**Our Case Number:** ACP-324383-26

**Re:** Proposed IDA Belview Infrastructure Development  
Belview, Slieverue, County Kilkenny

RE: Submission/Observation on Planning Application  
An Coimisiún Pleanála Case Reference: ABP 324383

Development Location: Section 177AE -IDA Belview Infrastructure Development, Belview,Slieverue, Co  
Kilkenny

Title: **Proposed Access Road Layout Sheet 1 of 2**

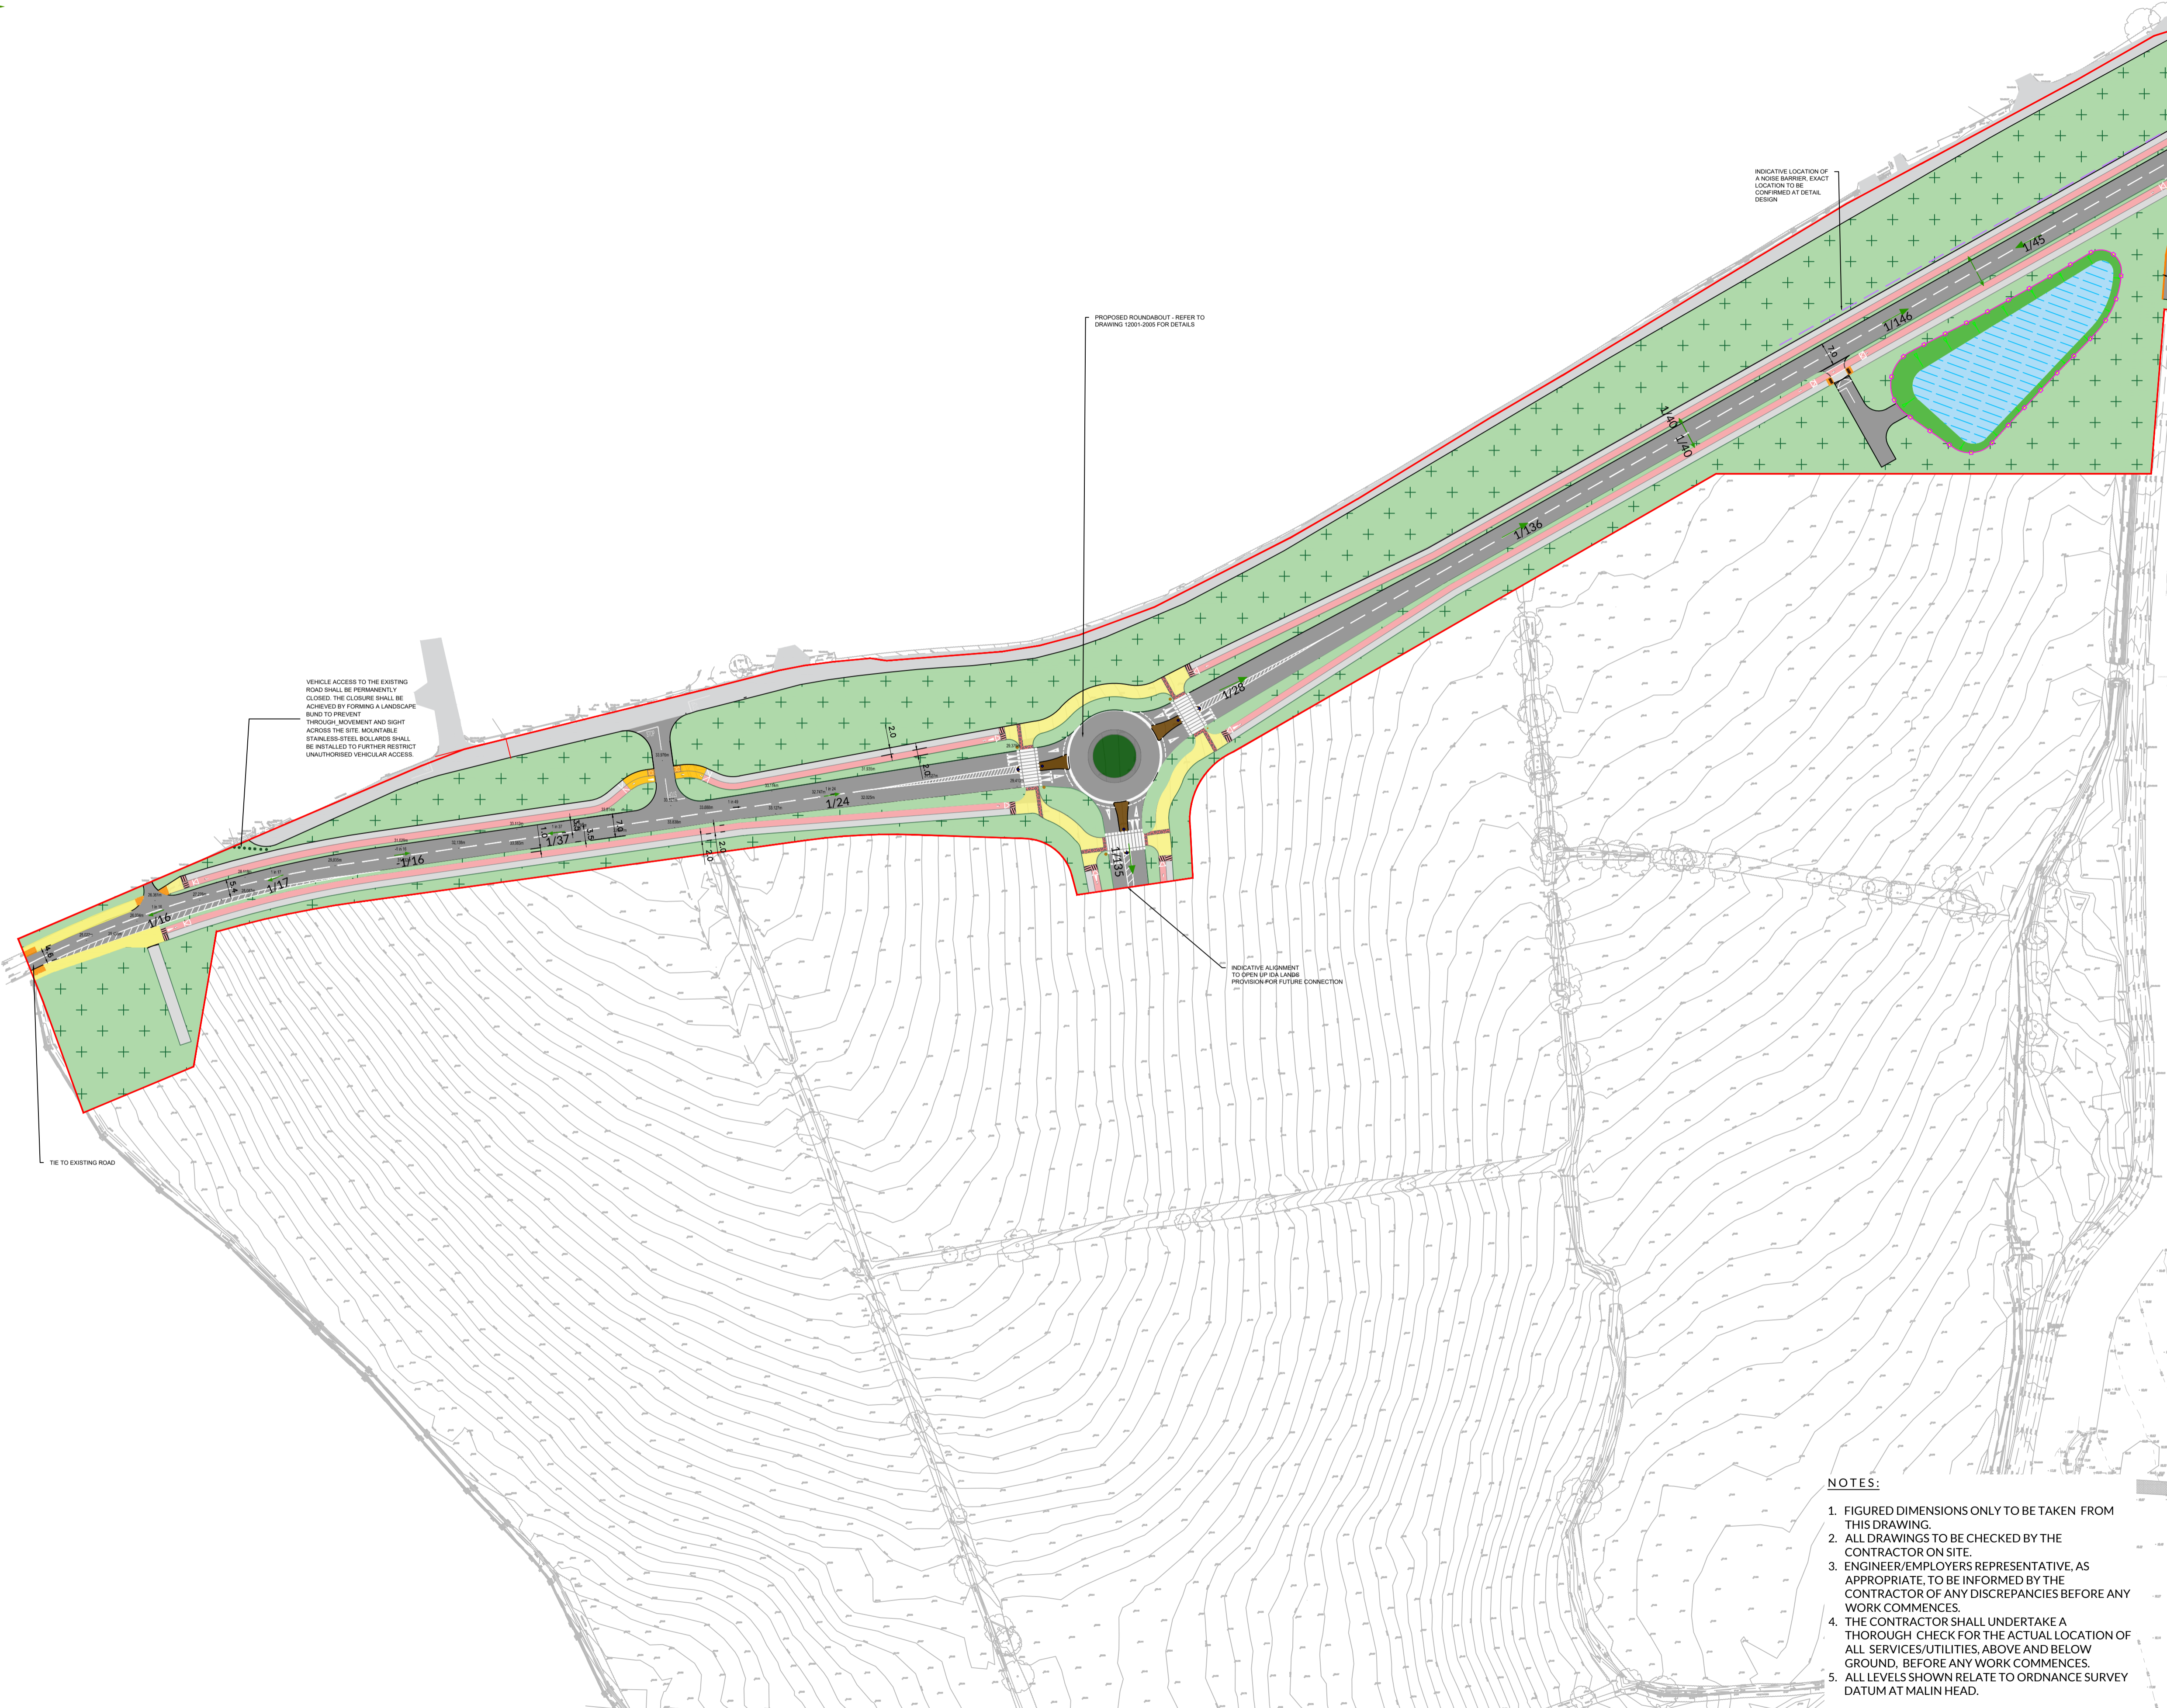
1. The proposed closing of the existing road to traffic by installing steel bollards just past the house and making it a pedestrian walk through is a cause for concern as Johns house is then placed in a cul de sac. Our concerns are people parking their cars outside the house and using the walk way as is already the case in the existing cul de sac further down the road.

6. Will there be a noise bank across from the house as the proposed new road will be quite close to the house.

Title: **Proposed Access Road Layout**  
**Sheet 2 of 2**

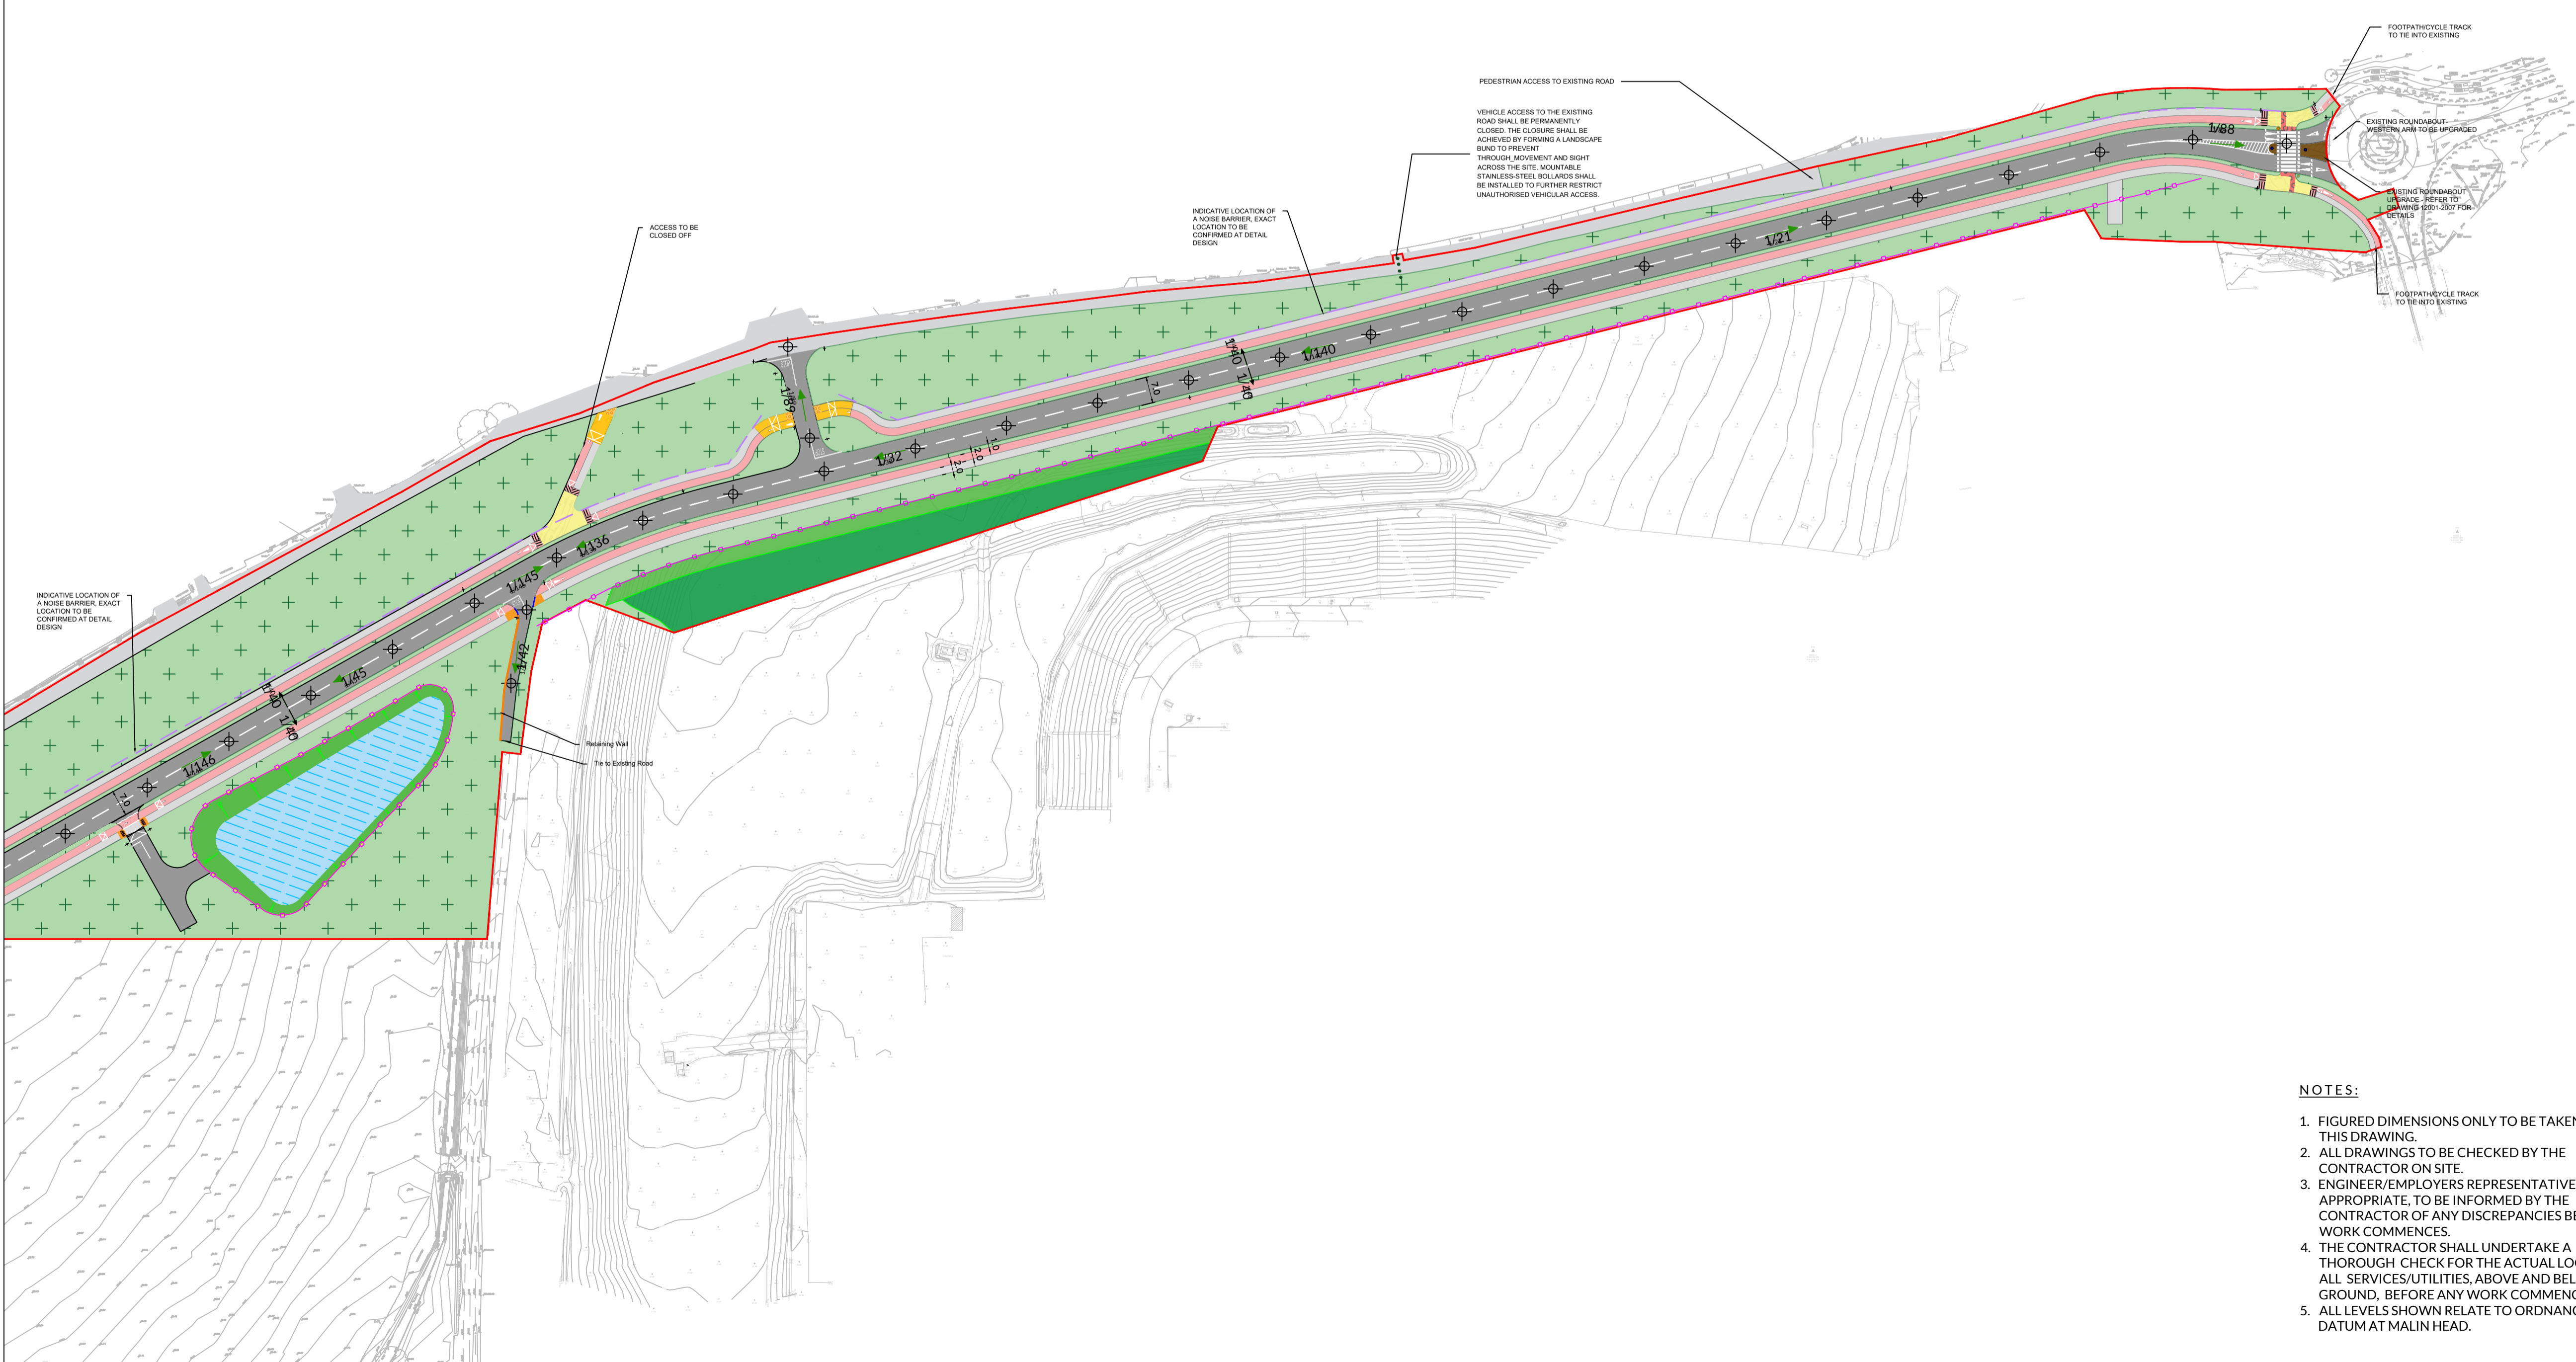
2. Will there be adequate access to the adjoining field at the house for tractor and trailer to enter and exit the field.
3. Access for bin lorry, post van, delivery van, ambulance etc. At the moment they turn at the existing roundabout at Glanbia but if the road is closed how will they access the house. An Analysis for this has been done for the Kilmurry lane area but doesn't seem to be for our area.

4. The area being used for dumping rubbish which is already happening at the minute.
5. Maintenance for the hedges if the road is closed how will the hedge cutter access.
